A303 Amesbury to Berwick Down

TR010025

**8.10.10 First Written Question - Draft Development
Consent Order (dDCO) (DCO.1)**

Version	Date	Status of Version
Rev 0	03.05.2019	Deadline 2 Issue

Drawing Title: **RIGHTS OF WAY AND ACCESS PLANS REGULATION 5(2)(k) & 5(2)(o) SHEET 3 OF 15**

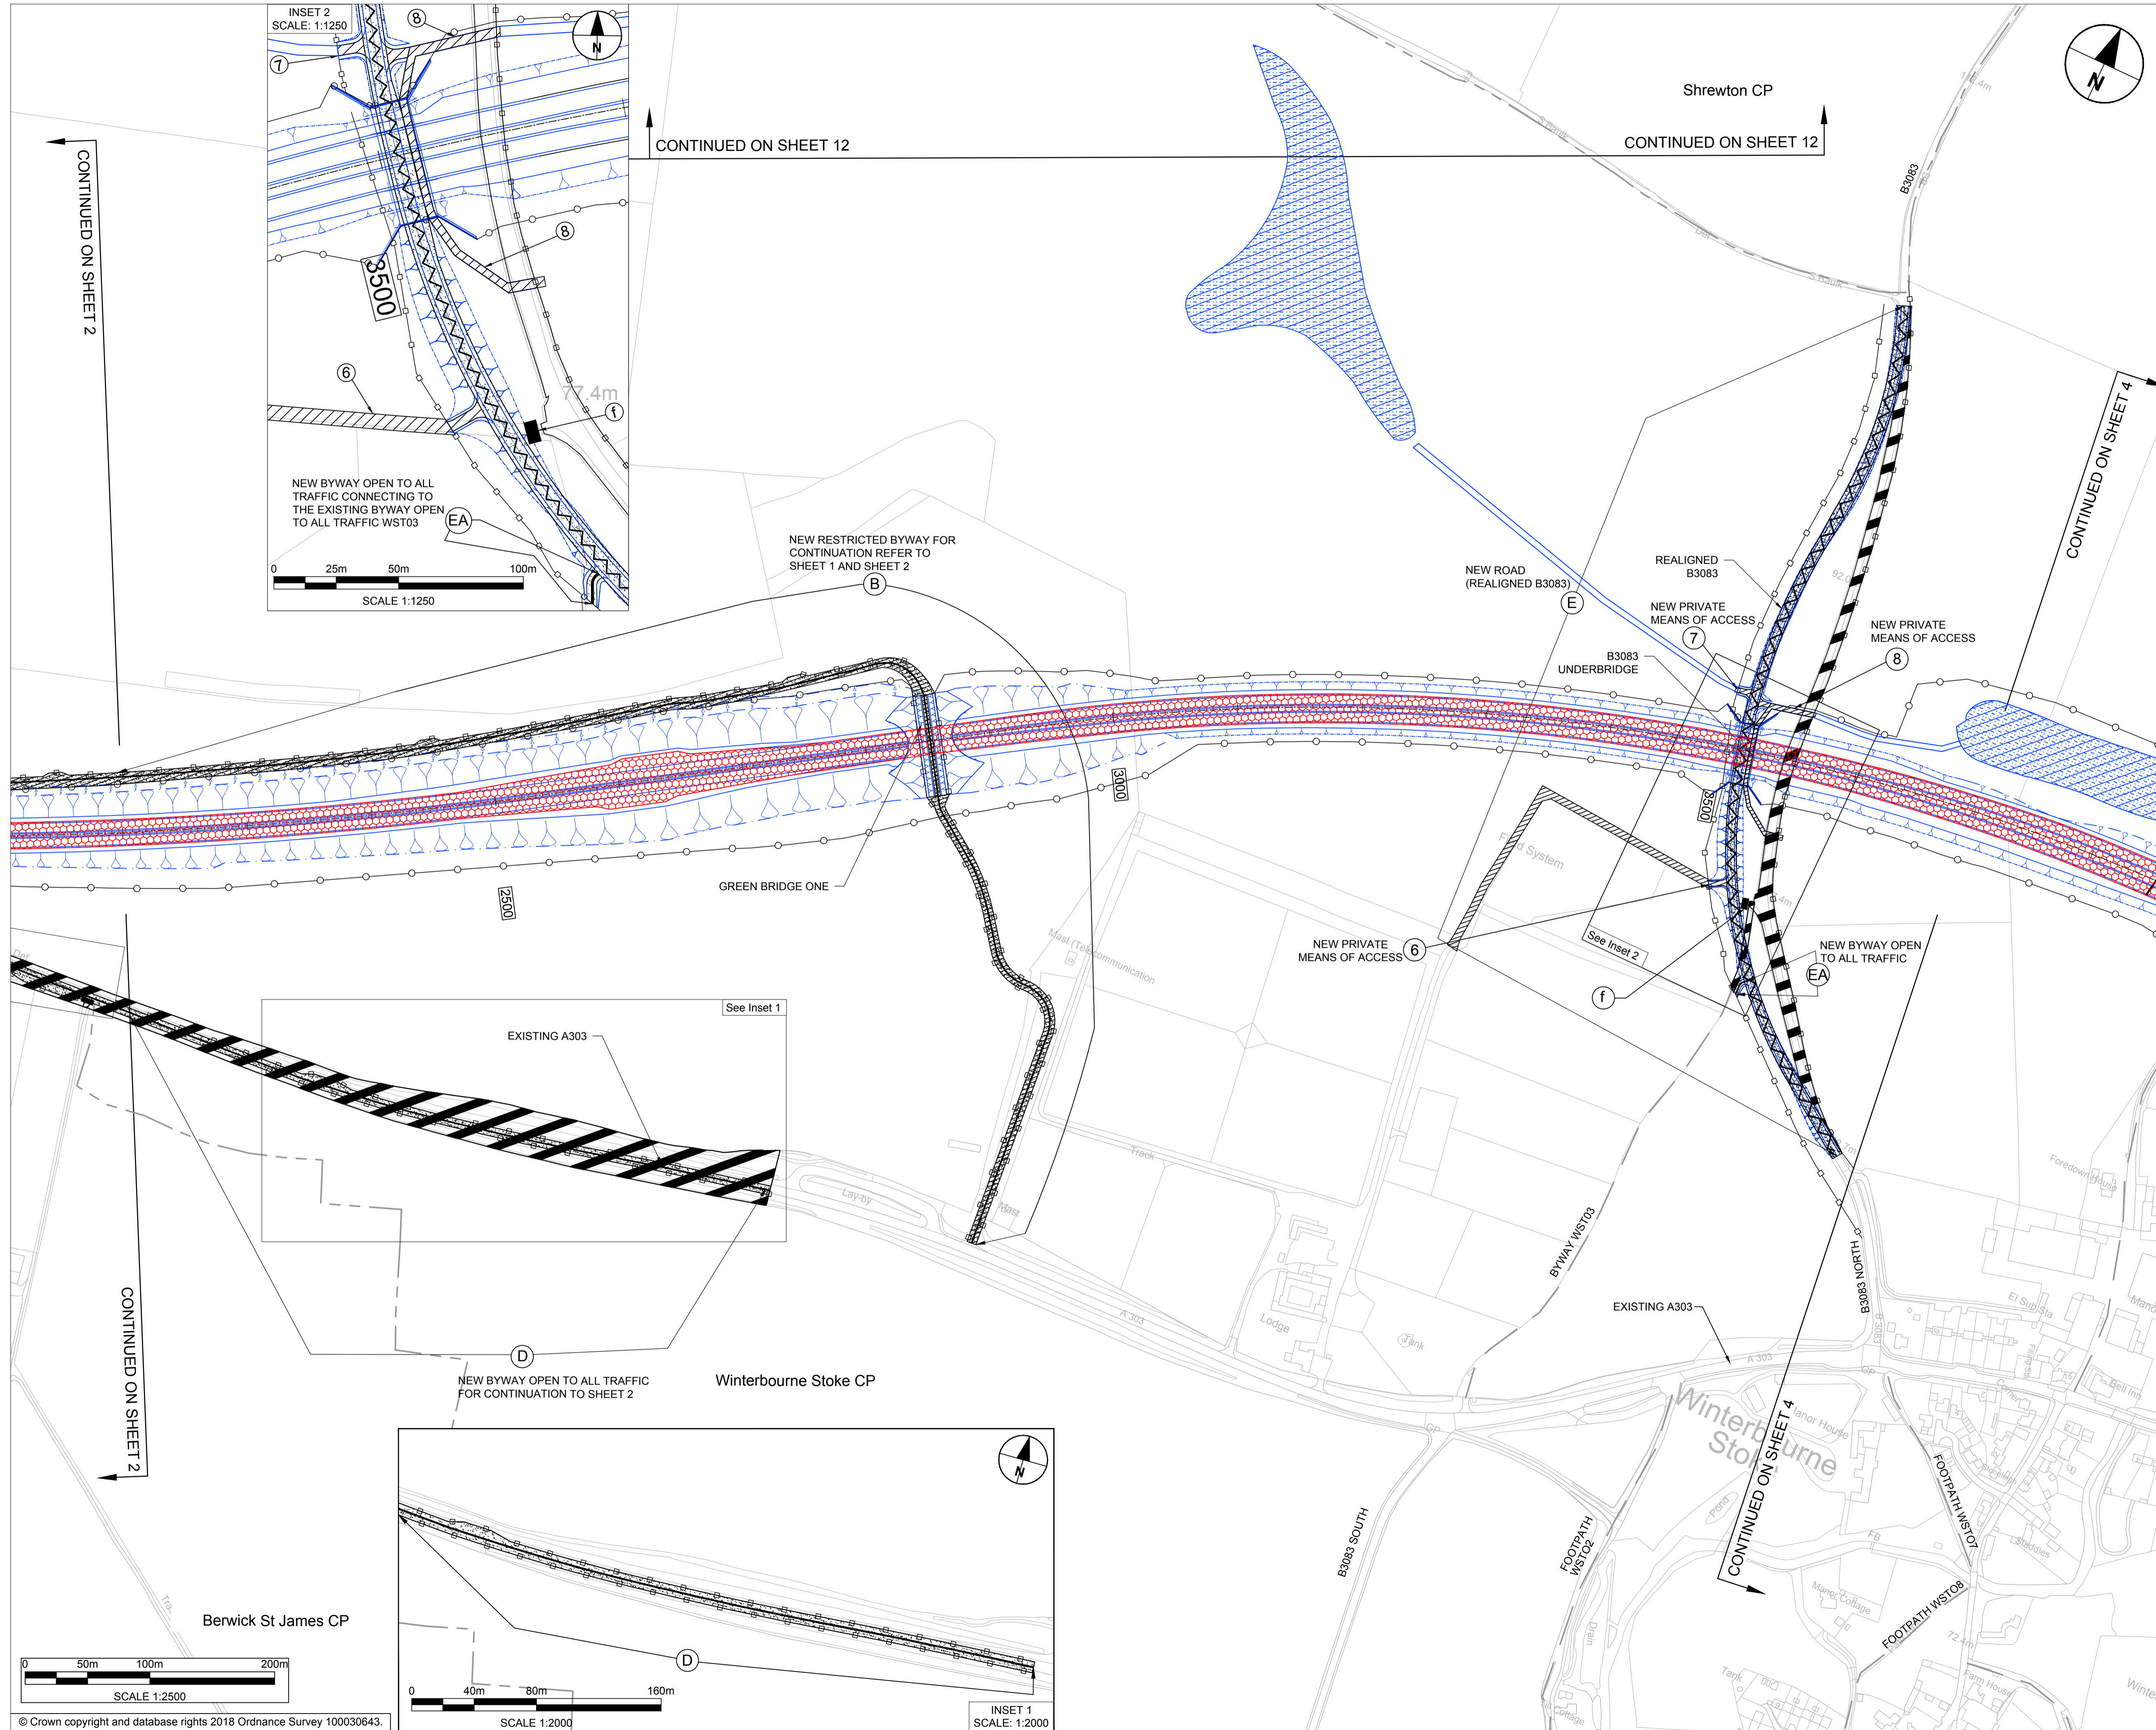
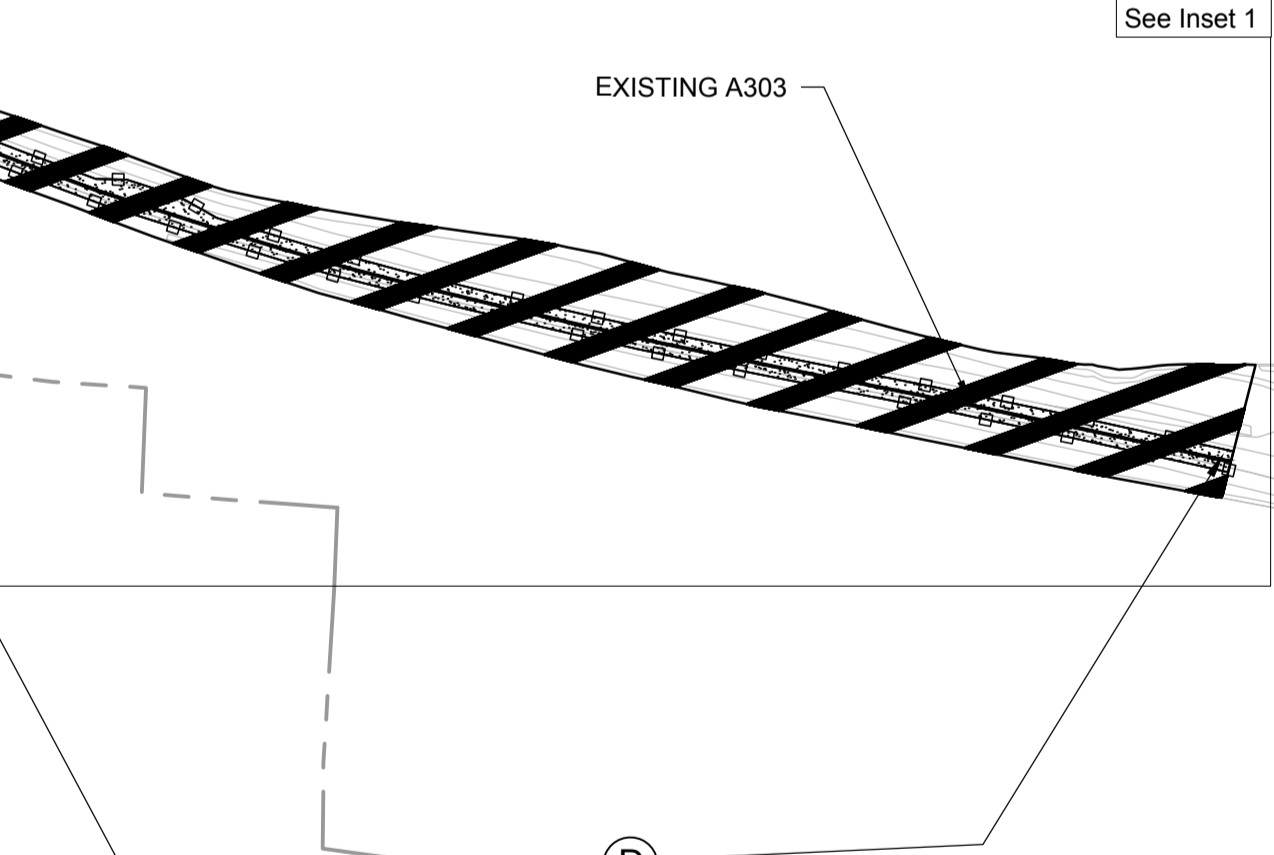
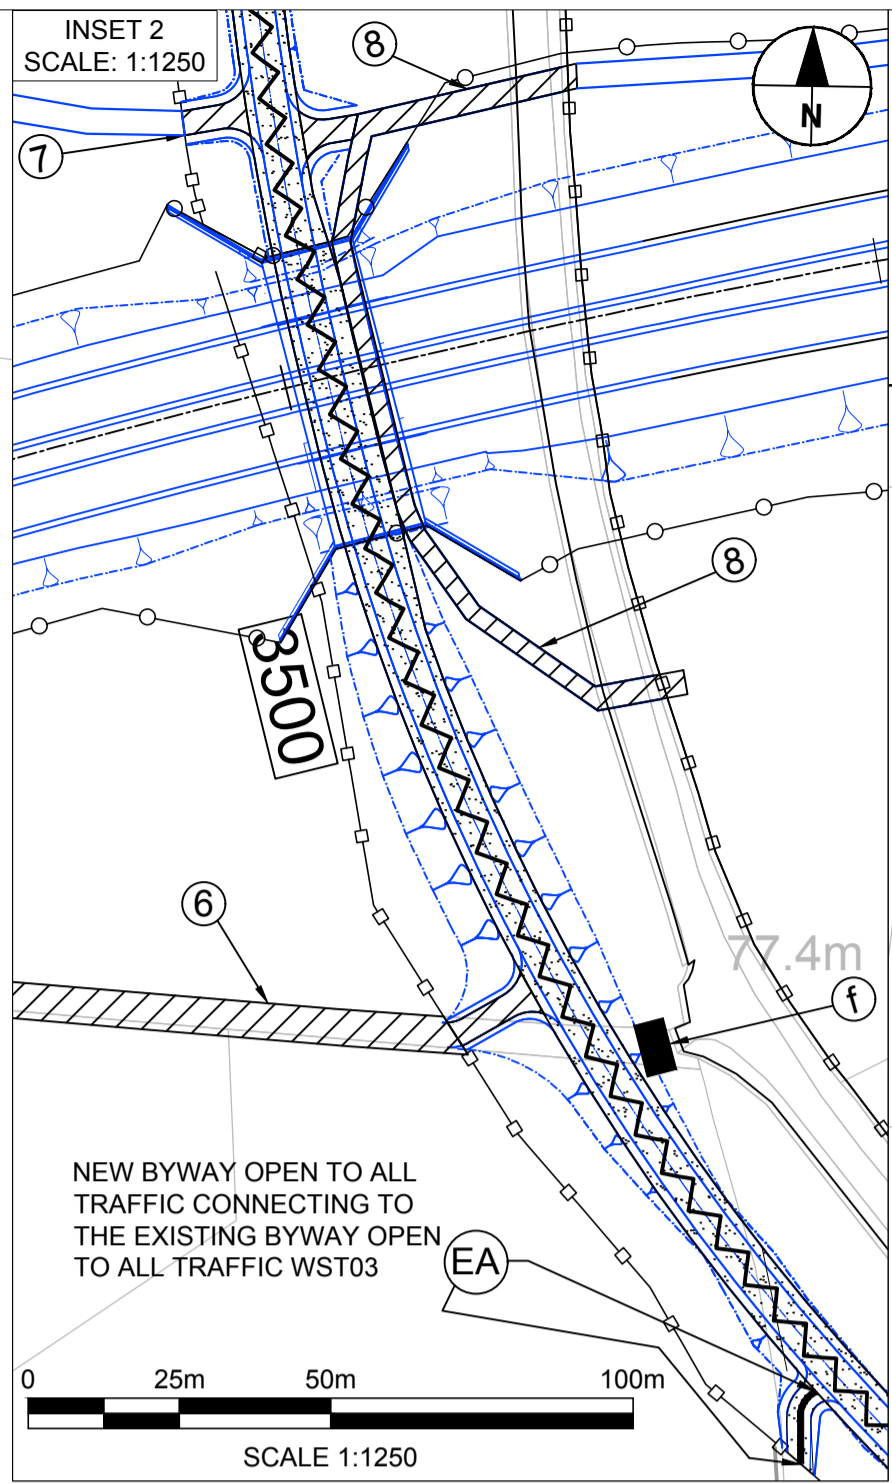
<p>ii. Furthermore, should Work No. 8 be further defined with reference to the detail on the Environmental Masterplan (Figure 2.5L) or alternative plan to secure the detail to the extent that it has been assessed in the ES?</p> <p>iii. There is no 'engineering detail' on the Parsonage Down reprofiling works as part of the engineering section drawings [APP-010] and [APP-011]. It is also unclear why the limits of deviation (LoD) for Work No. 8 have been drawn as they have on the Works Plans (sheets 3 and 12 of [APP-008]. Based on the general arrangement plans (sheets 3 and 12 of [APP-012], it would appear that there are "<i>proposed landscape profiling</i>" works to the south of the LoD of Work No. 8, with the whole area presented on the general arrangements plans as a single, continuous unit. Please clarify and explain these points?</p>	<p>ii. Except where specifically secured, the Environmental Masterplan is indicative only. Work No.8 is defined by reference to the non-linear work lateral limits of deviation shown on the Works Plans [APP-008], and in the vertical plane is constrained by the upwards/downwards vertical limits of deviation specifically allocated to Work No. 8 in the Table within article 7(4). The parameters of assessment applied to the assessment of Work No. 8 in the ES, see Chapter 2 of the Environmental Statement [APP-040], are based on those horizontal and vertical limits of deviation.</p> <p>iii. In respect of the absence of a sheet in the Engineering Section Drawings (Plan and Profiles) [APP-010] showing the profiles of the East of Parsonage Down re-profiling described in Work No.8, this is deliberate. At this stage the precise levels cannot, and should not be defined. This is because the levels will necessarily flow from the detailed design. The factors that are relevant to the final form of Work No.8 include:</p> <ul style="list-style-type: none"> • the quantity of suitable excavated material generated; • the quantity of excavated material that will be used elsewhere in the Scheme; • the measures necessary to account for the presence of any archaeological remains that are encountered on the land; • the form necessary to achieve the desired landscape mitigation; • the measures necessary to ensure that slopes are stable; • the measures relating to drainage.

<p>However, it should be noted that the final form of Work No.8 would be subject to the Secretary of State's approval, following consultation with the planning authority, under requirement 8 of Schedule 2 to the draft DCO. Requirement 8 requires a landscaping scheme to be approved before the commencement of any part of the authorised development and requires the approved landscaping scheme to be based on the mitigation measures included in the environmental statement.</p> <p>In terms of how the non-linear limits of deviation have been drawn for Work No.8, again this is deliberate and carefully considered. Work No.8 shows the location of the deposition of excavated material, landscape re-profiling and the area within which the new chalk grassland habitat would be provided. As noted in (i) and (ii) above landscape re-profiling is required elsewhere within the Scheme which explains why landscape re-profiling shown on sheet 3 of the General Arrangement Plans [APP-012] extends beyond the bounds of Work No.8.</p>
